**From:** Loveday, Mike, Vodafone Group <mike.loveday@vodafone.com>  
**Sent:** Thursday, 9 May 2013 3:07 PM  
**To:** Public Hazzard's Office Email  
**Subject:** [Correction and Apology]: MP 09\_0066 MOD 6 - Chatswood Albert Ave/Thomas St Development Concerns

**From:** Loveday, Mike, Vodafone Group  
**Sent:** Thursday, 2 May 2013 5:12 PM  
**To:** The Hon. Brad Hazzard (MLA), Minister for Planning and Infrastructure  
**Subject:** MP 09\_0066 MOD 6 - Chatswood Albert Ave/Thomas St Development Concerns

SHADOW DIAGRAM  
21 JUN

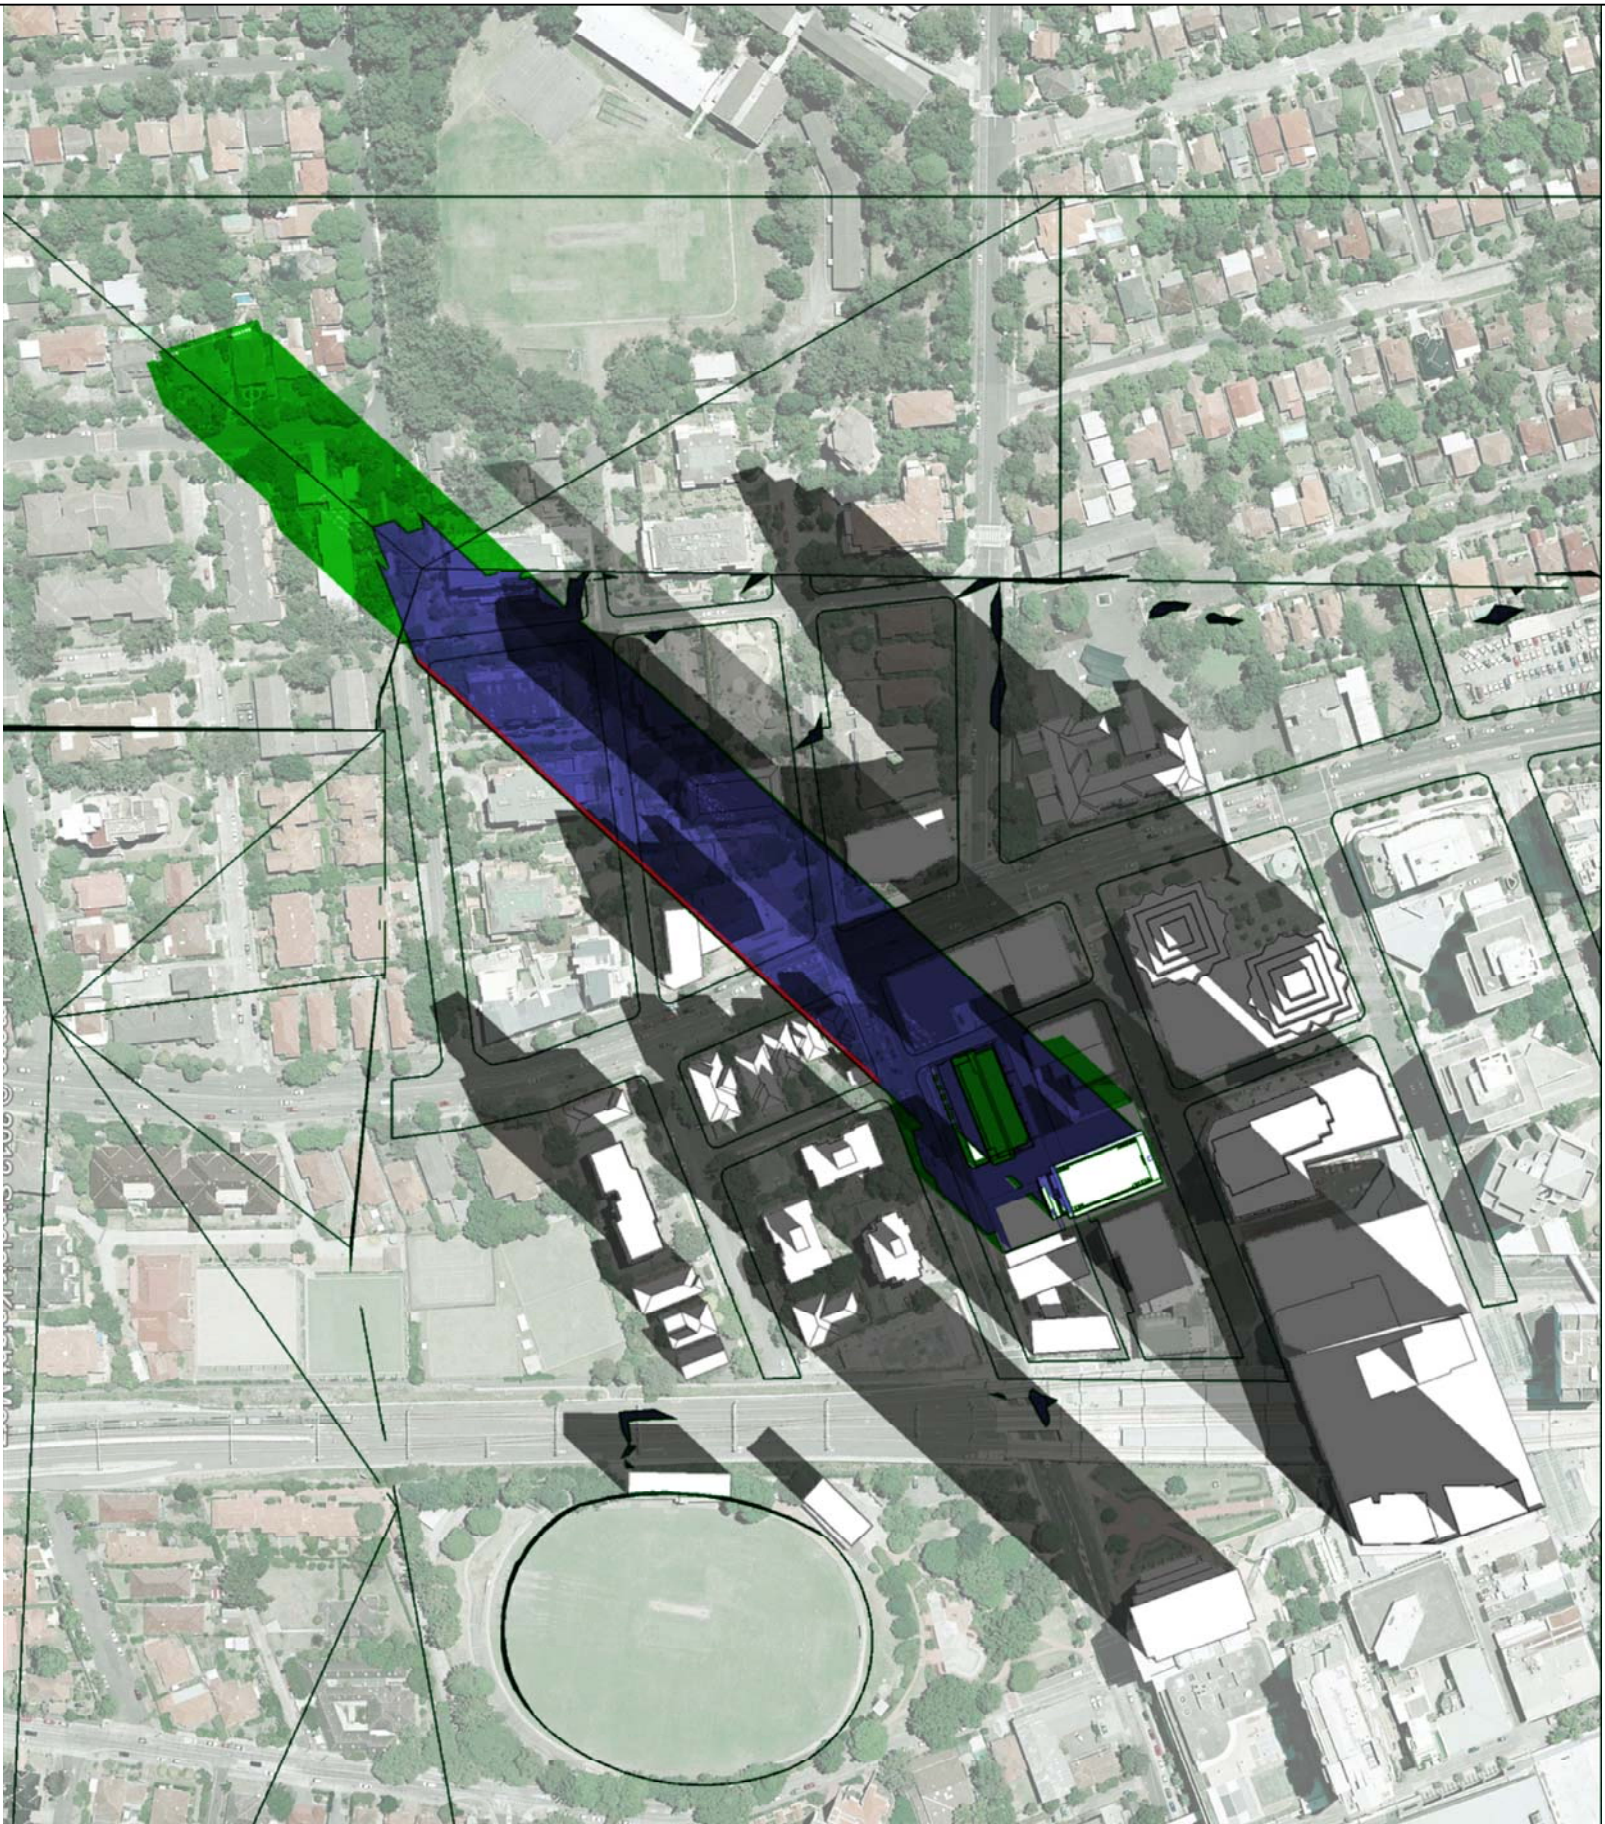
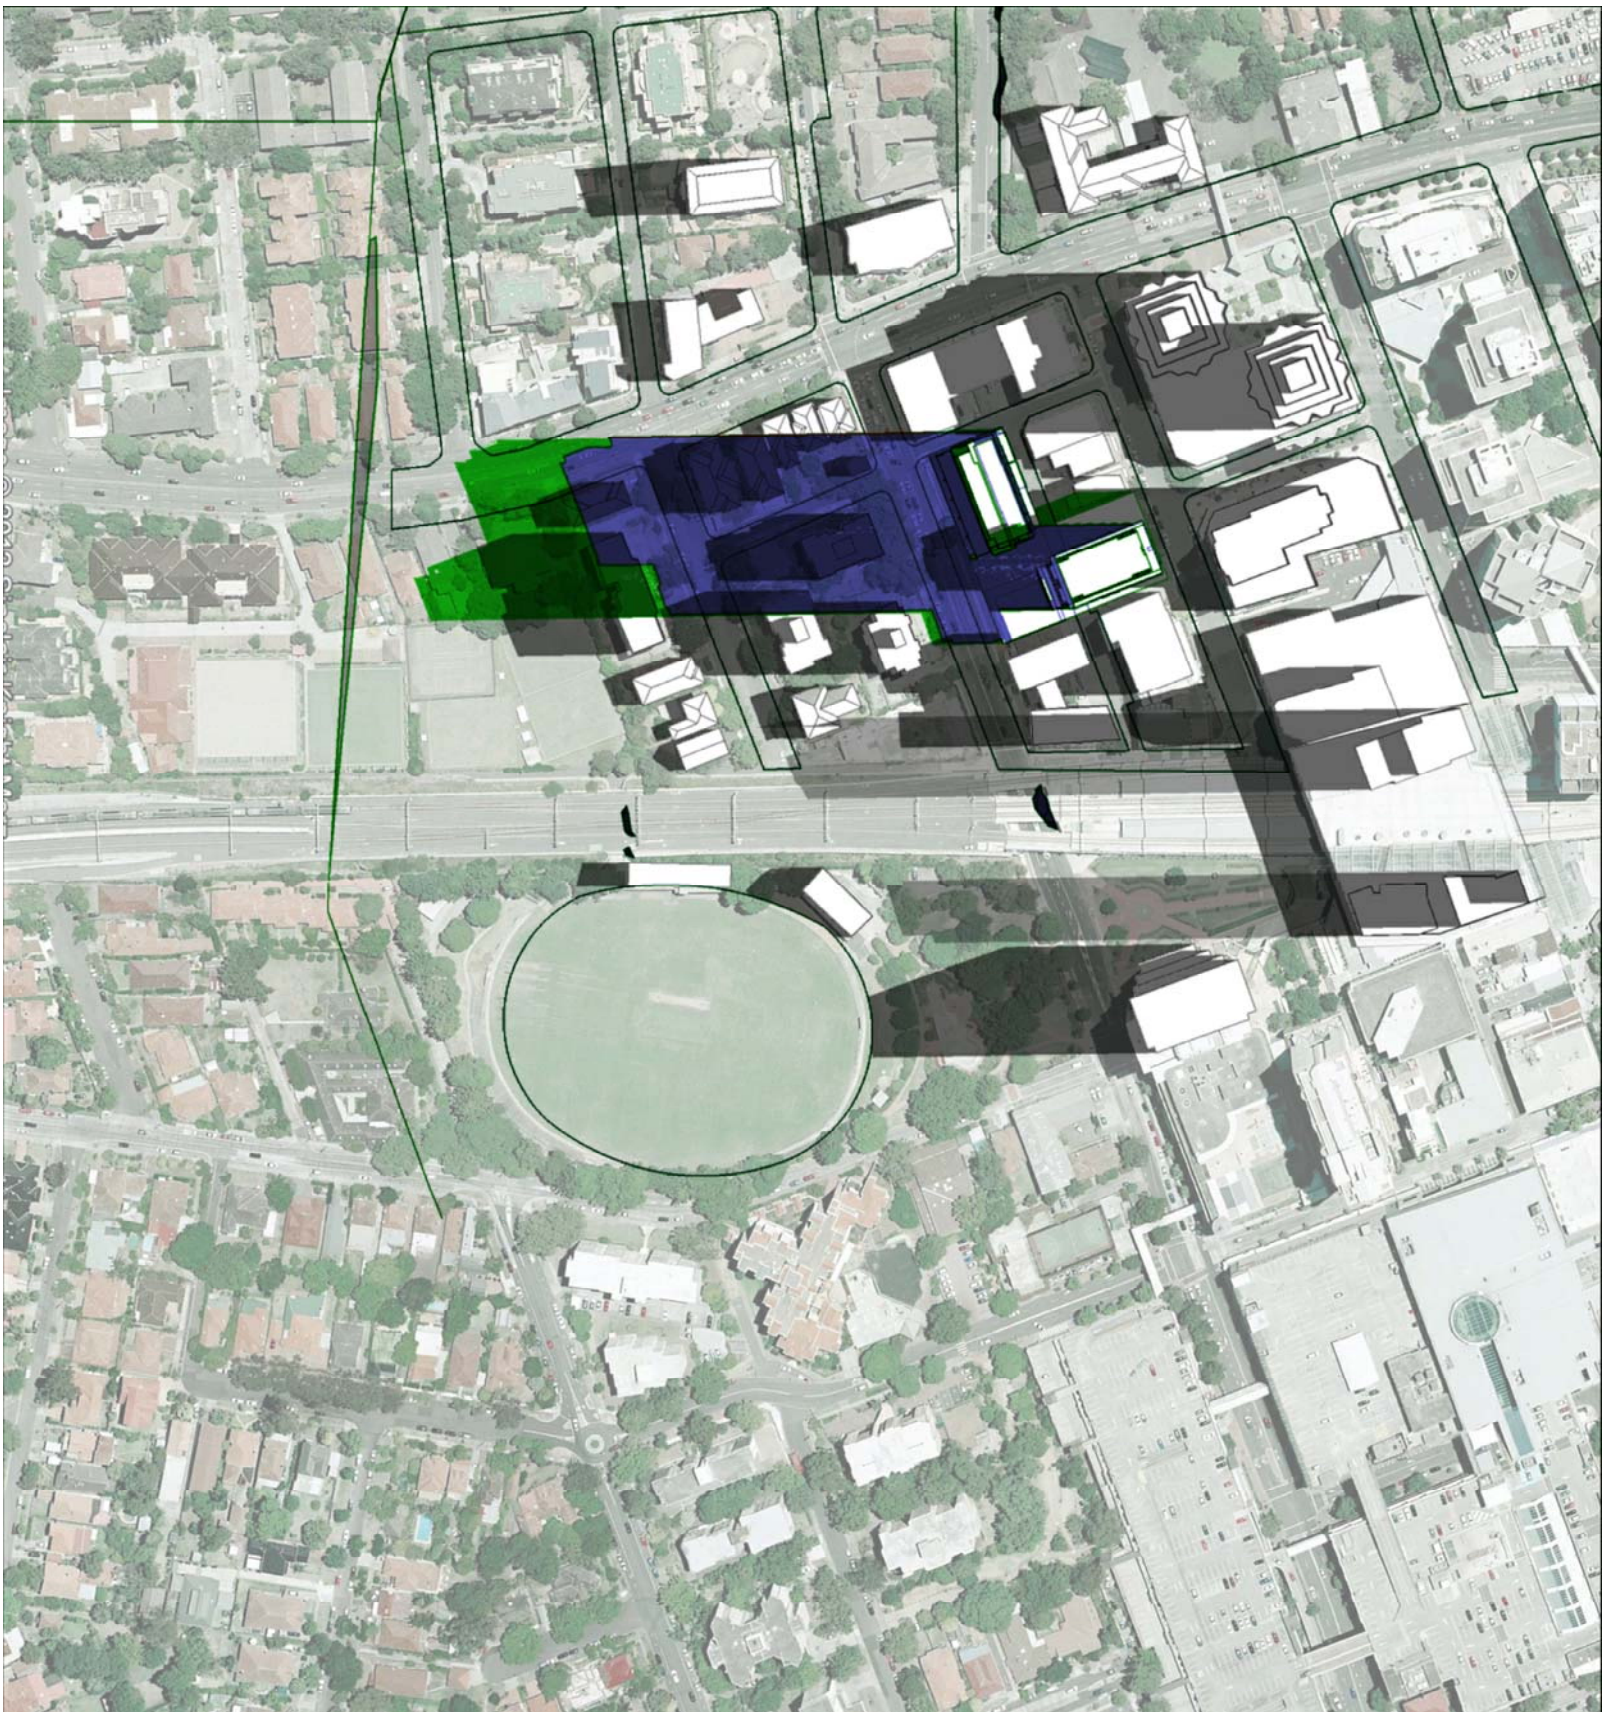
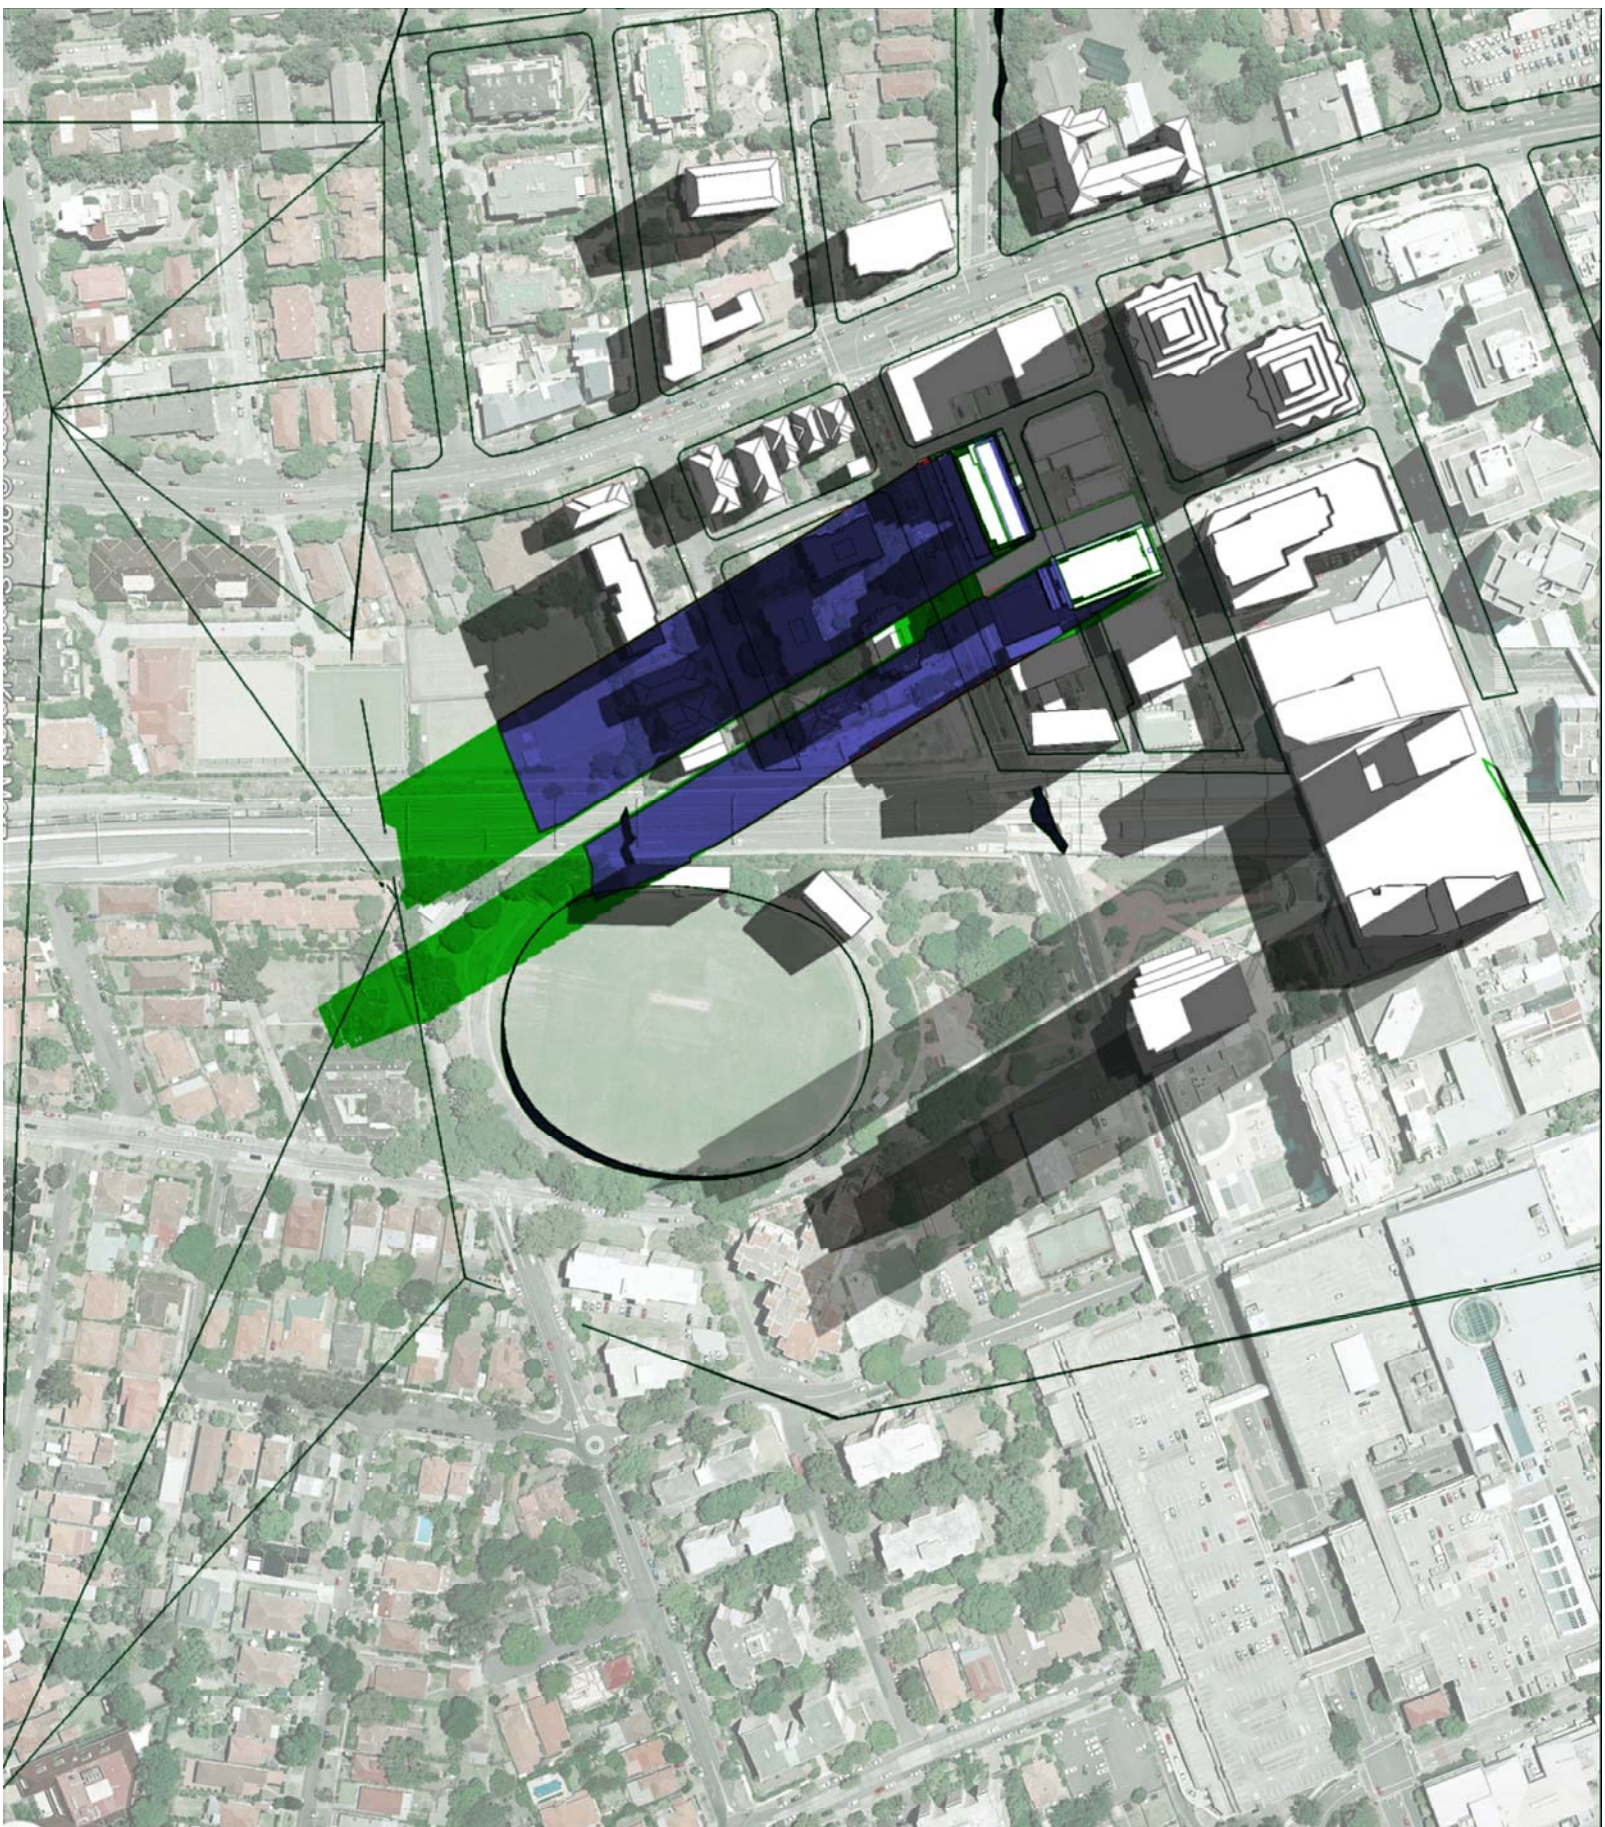
Tower 2 in particular being longways across the block (facing north) which due to the bulk form of the rectangular profile will cause excessive massing impact, loss of solar access, and shadowing to all of the smaller 3-4 and 8 storey residential buildings to the immediate south on the residential fringe of the CBD and the prized nationally significant Croquet and bowling greens and Chatswood Oval.

Massing Impact from the bulk form of Tower-2 as well as loss of solar access and shadowing will be further excessive given that this tower is longways across the site. Being a north facing rectangular bulk form, it will shadow the much smaller residential fringe to the south including the nationally prized Chatswood Croquet and Bowling Greens and Chatswood Oval.
